1. Please add setbacks from all permanent structures to property lines (sheds and existing residence are missing setbacks, for example).
  2. Please also add easements as noted on the title commitment and plat. (all side and rear lot lines have 25-foot utility easement along the side property line (southern side) per the plat.)
  3. Please add site data table. Please refer to site plan example and include ALL property and building information shown on that plan, shown directly on the plan or on the data table, as appropriate per the examples. Access the site plan example via this link: <https://assets-planningdevelopment.elpasoco.com/wp-content/uploads/FAQ/SitePlanExampleSmall.jpg>
- \*Don't forget to include all information on site plan example, including parcel ID number.

# Site Plan Drawing\_V1.pdf Markup Summary

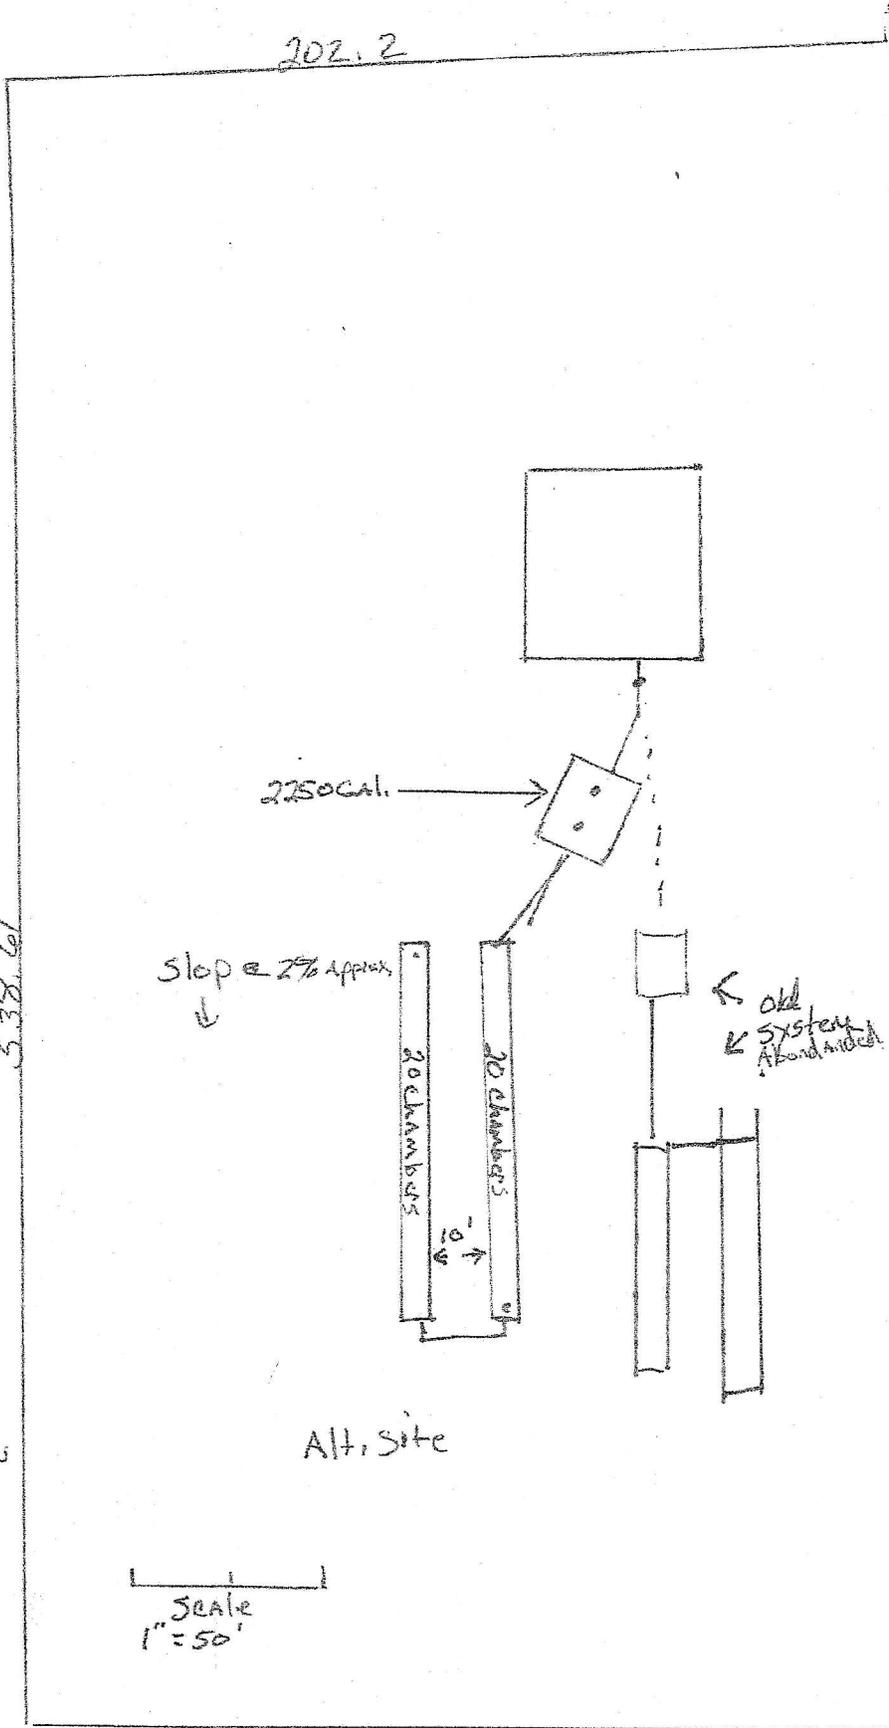
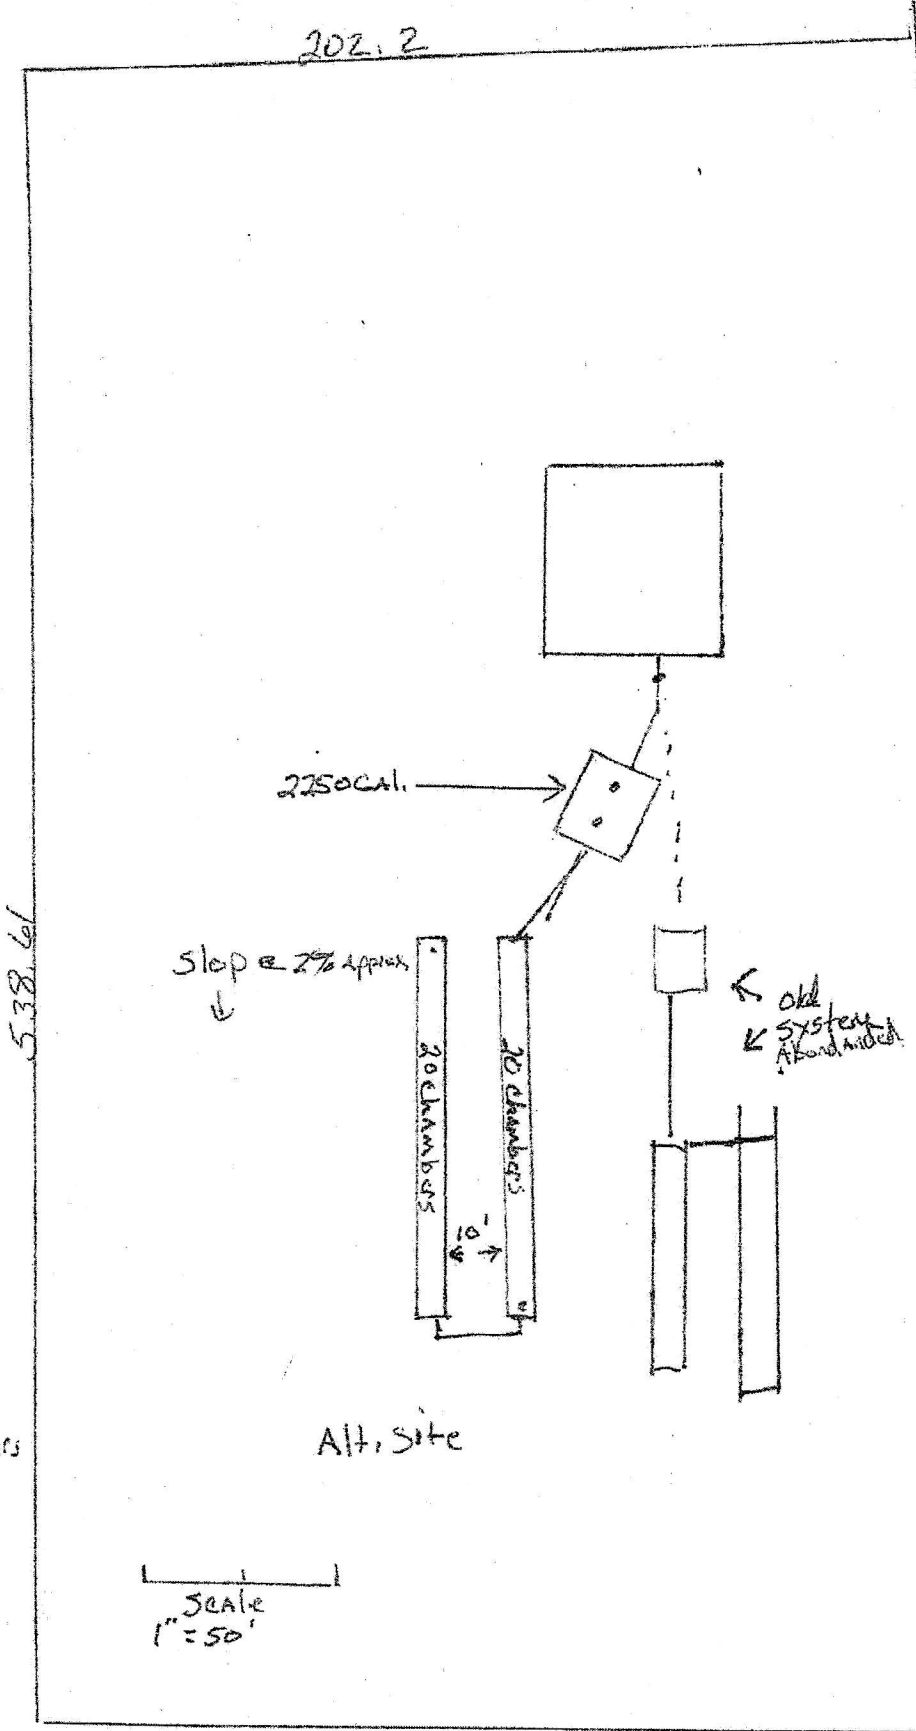
Please update to provide a scale for the site plan.

PCD Note: existing shed is encroaching into setback and is unpermitted. As such, please note that it cannot be improved or expanded upon without approval by the PCD Dept. Director to remedy the nonconformity.

The approved site plan from 2016 (project file ADD1610) identified the shed as "non-permanent". If this is the case, then please note same.
